**Case Officer:** Shona King

**Recommendation:** Approve

**Applicant:** H Smart

**Proposal:** Demolition of existing garage to rear and single storey extension to front. Internal refurbishment and reconfiguration.

IVY COTTAGE, 32 HIGH STREET, BODICOTE, OX15 4BP	P1	211105	Planning Issue				001_02_104_P1
							South Elevation of Wall to Broad Gap
							Scale 1:50 at A3

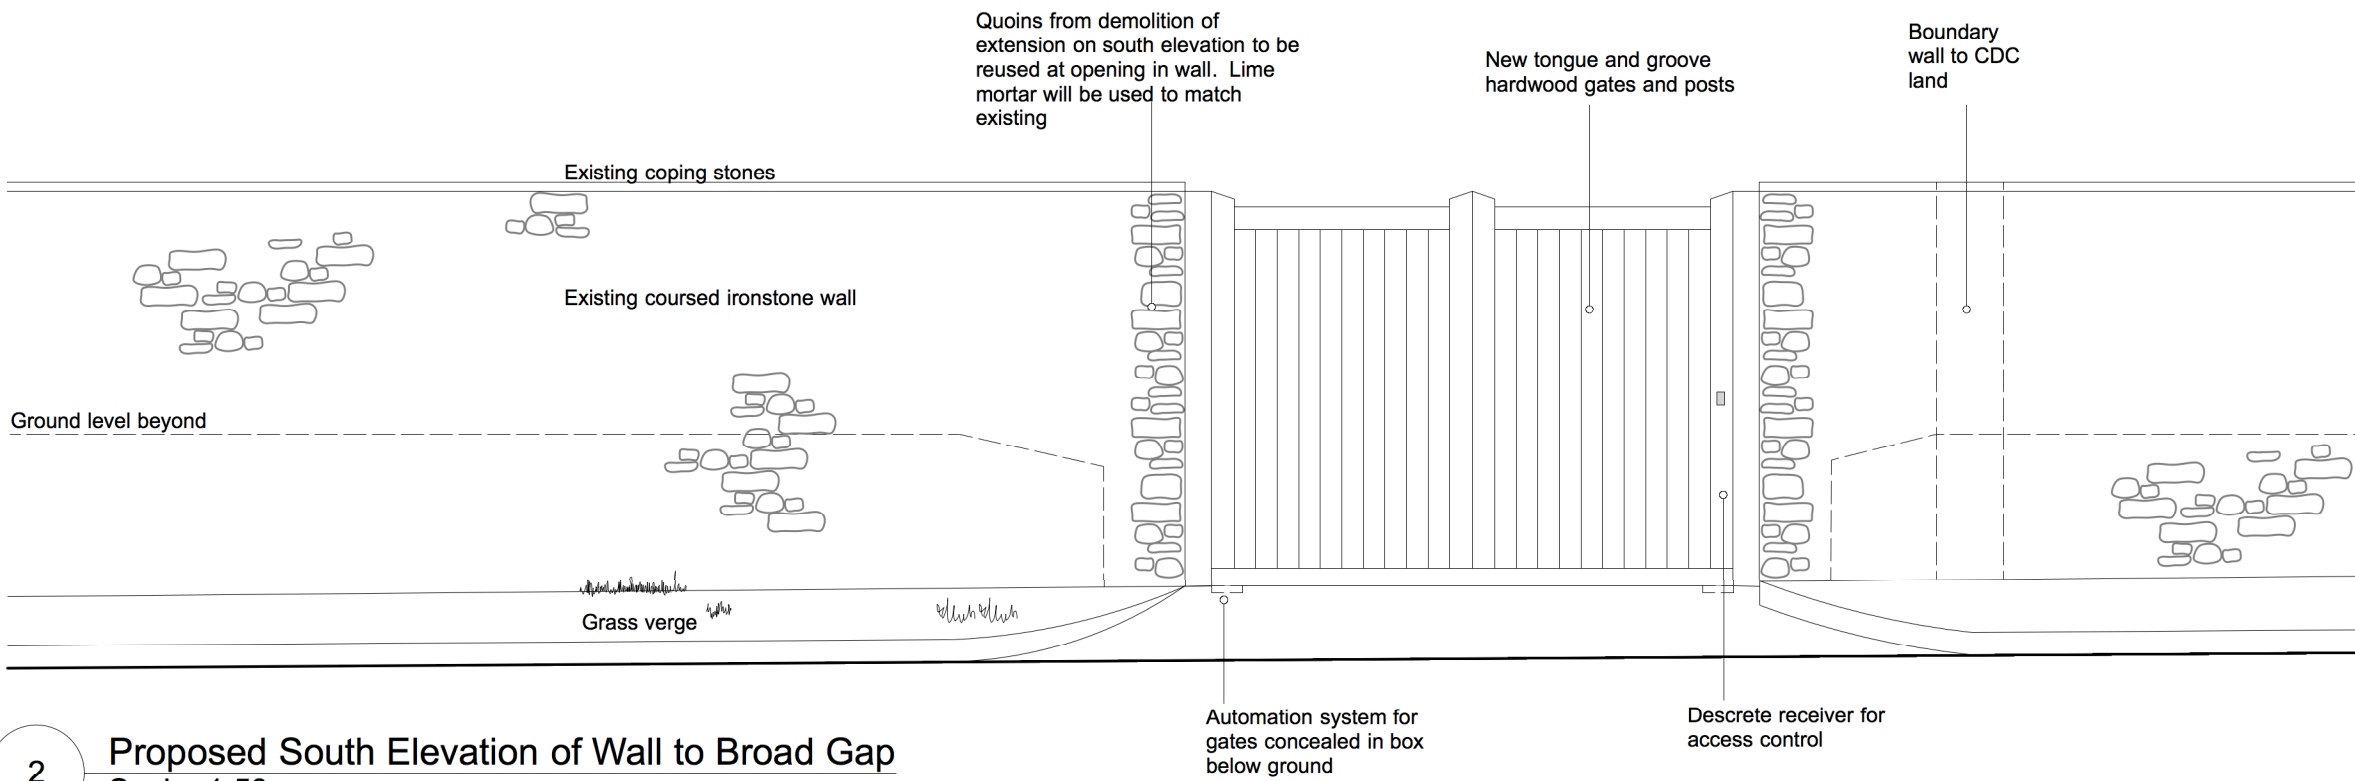
There are concerns with this aspect of the proposals which include the demolition of a section of wall along Broad Gap.

The high boundary walls are a significant feature of the Bodicote Conservation Area. The Appraisal states 'The street pattern in the Northern Village area is dominated by the front boundary walls of properties therefore these are really important in retaining the character of this part of Bodicote. Regular maintenance of both Ironstone wall and capping stones is essential' and 'Along Broad Gap the means of enclosure is a key element in creating a distinctive character, the high (in some places over 2 metres) stone walls, including those of Bodicote House, obscuring the houses behind..... The walls within this area are generally in good condition although in some areas the use of cement mortar has caused accelerated decay in the wall materials. Stone coping is used on 20 the higher boundary walls although there are also examples of cement haunches and upright stone capping.'

The boundary walls also contribute to the setting of Ivy Cottage and were potentially associated with Bodicote House. The wall to the west is listed in its own right, but the wall to the south of the cottage is likely to be curtilage listed either to Ivy Cottage or Bodicote House.

It is recommended that this aspect is withdrawn from the application.

- 6.4. CONSERVATION OFFICER: (Final comments): No objections following the revised details and the heritage statement

Sections DD Showing  
Existing and Proposed Structure

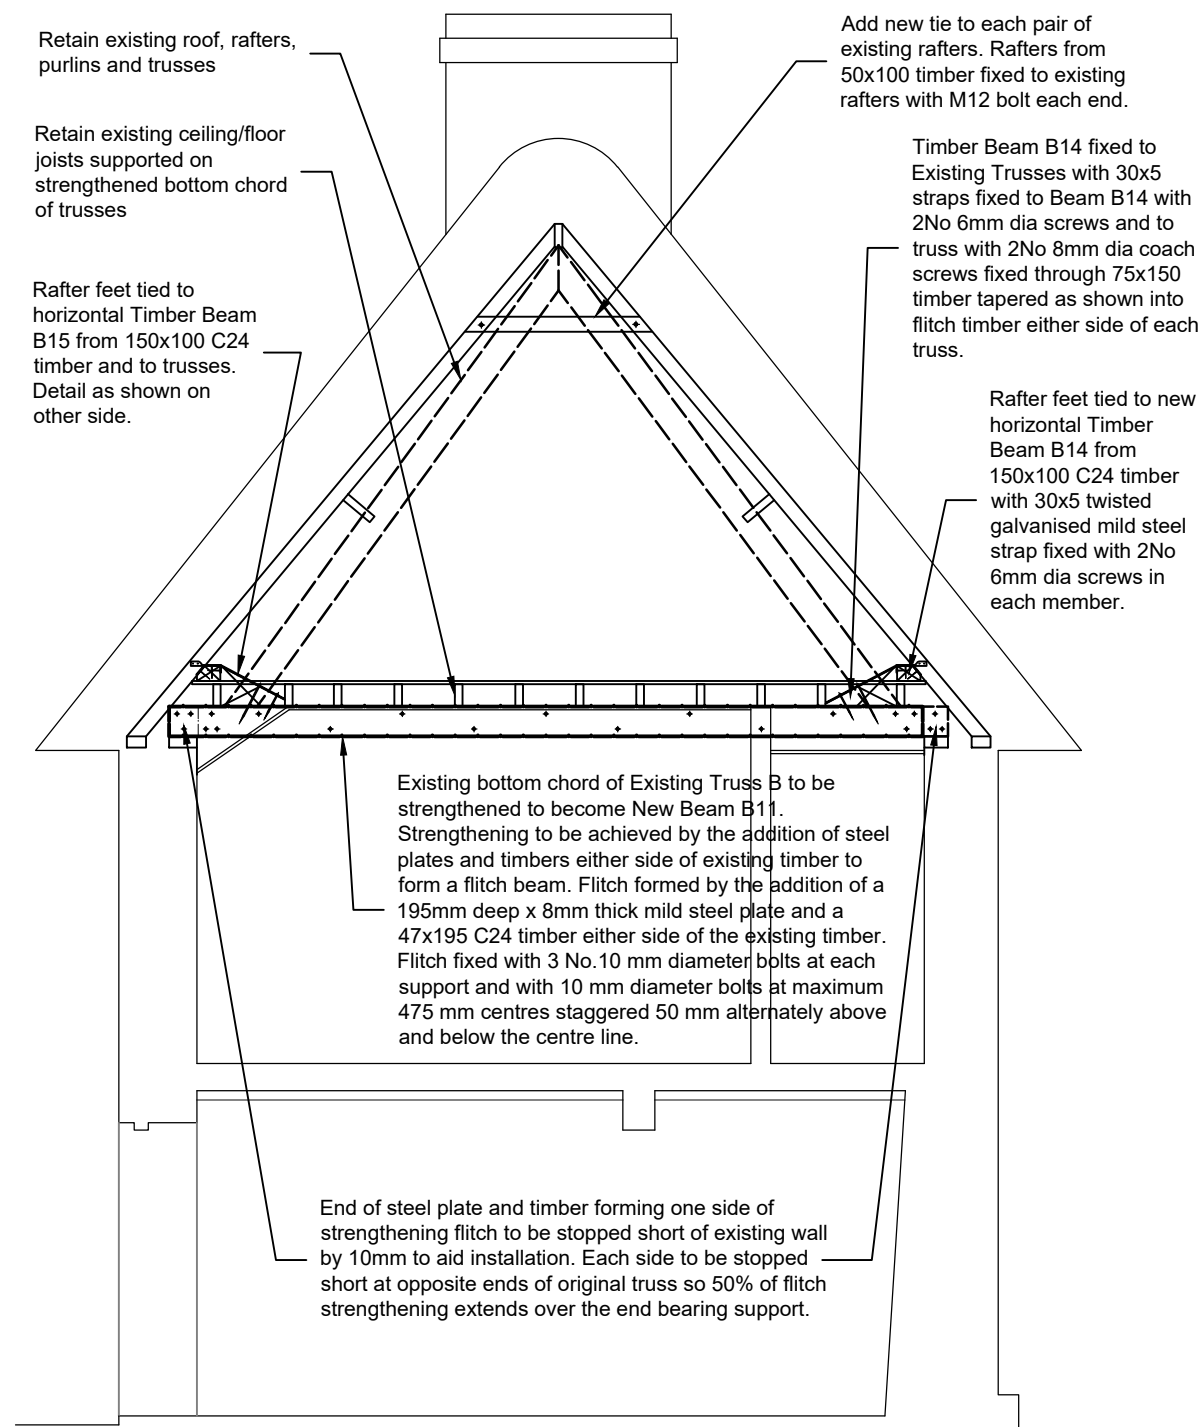
There are some structural alterations proposed to the building and whilst the alterations have been detailed there is no structural engineers report outlining what the issues are, why the interventions are necessary and what options have been considered. This should be submitted prior to the determination of the application.

IVY COTTAGE, 32 HIGH STREET, BODICOTE, OX15 4BP	P1	220107	Planning Issue			001_05_100_P1
						Proposed Window and Door Details
						Scale 1:10 at A3

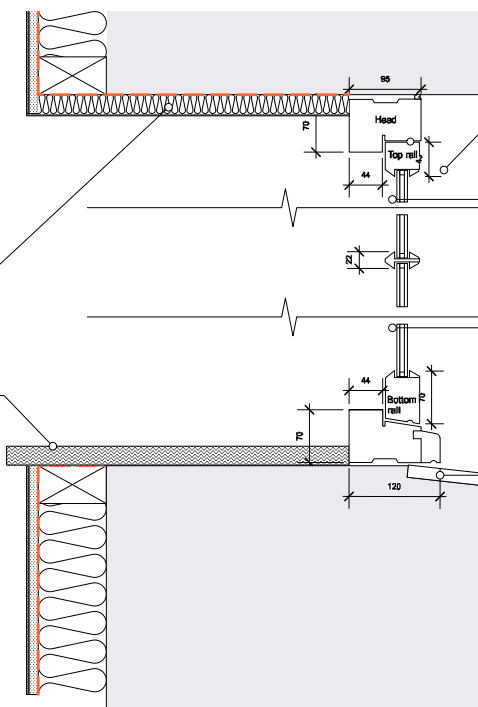
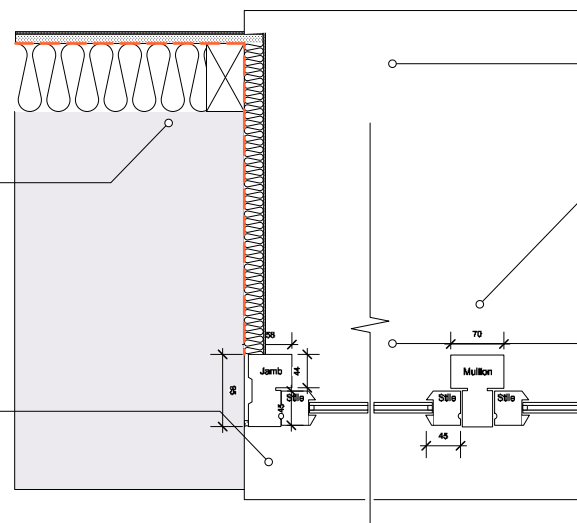
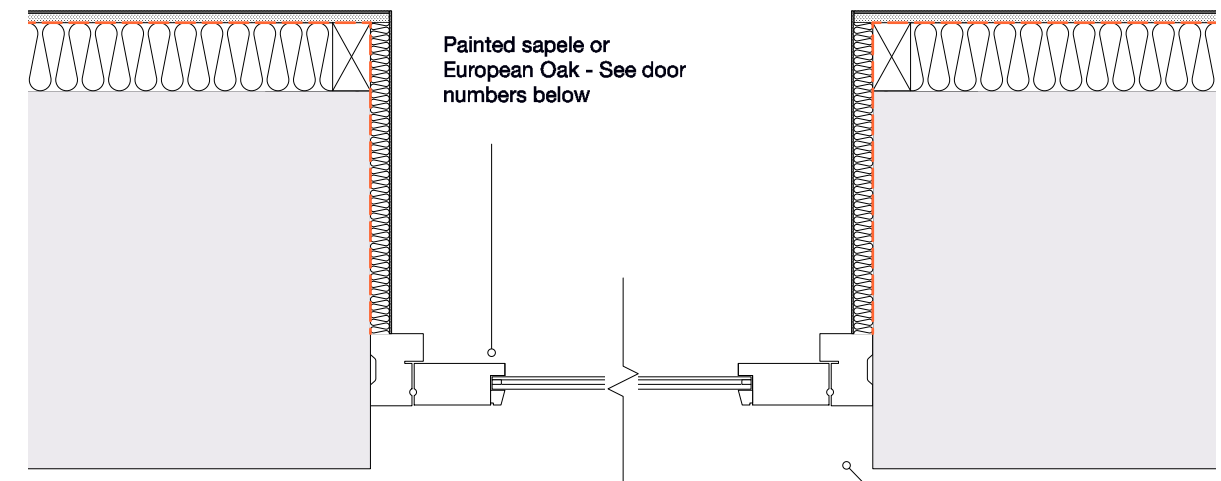
- No objections to proposed replacement windows / doors / openings.
- Details of repair / refurbishment of existing windows.
- Stone sample panel for making good of the stonework following the demolition of the 20th century extension.
- No objection to repointing provided a lime mortar is used.
- No objection to removal and replacement of delaminating stonework, but further details are required in the form of a method statement and justification statement.
- No objection to blocking of windows in later extension, but concerns with proposal to paint brickwork white. An alternative solution may be required.
- further details / justification and method statement relating to proposed vents required.
- There are some concerns with the raising of the height of the chimney and further details are required about why this is necessary.
